Harnett County
420 McKinney Pkwy
LILLINGTON, NC 27546
Phone:
Fax:

SUBJECT: BRES2307-0070
BUILDING RESIDENTIAL

Here are the results of all Inspections located at **5985 RAWLS CHURCH RD:**

Result: DISAPPROVED

BASEMENT SKETCH

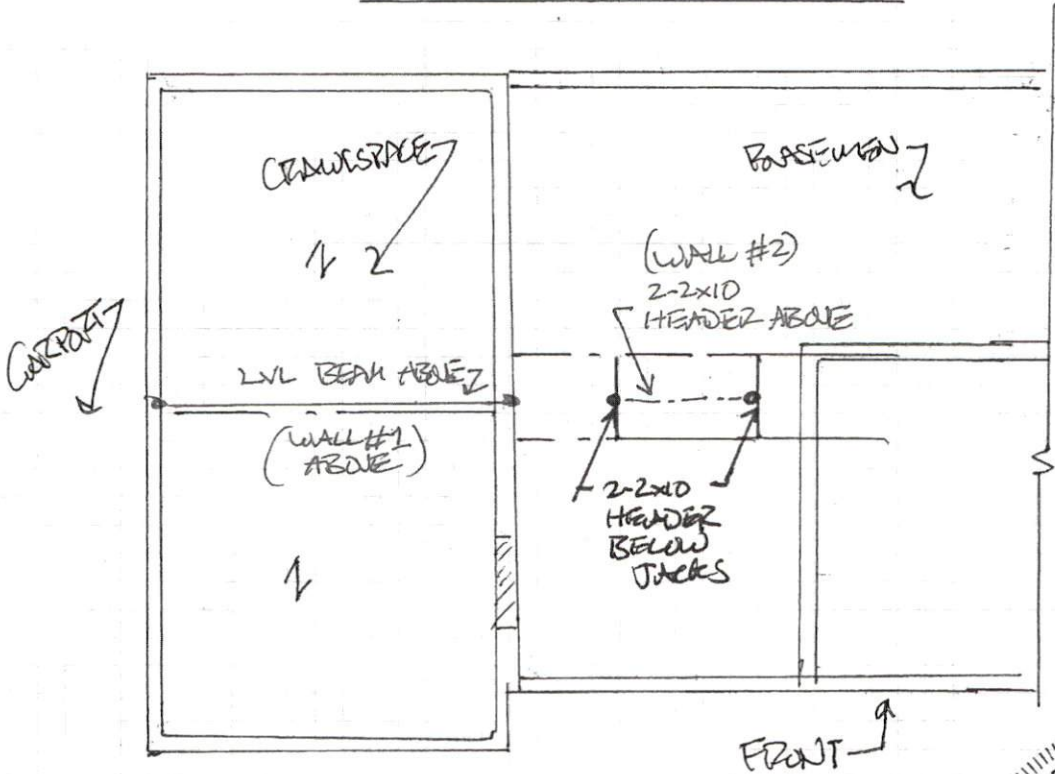
1. Wire nuts on not landed wires in panel, 2. Joist hangers above range 3. Wall two need double 2x10s under jacks per letter n basement and joist hangers at same. 4. fire block penetrations to top and bottom plate.
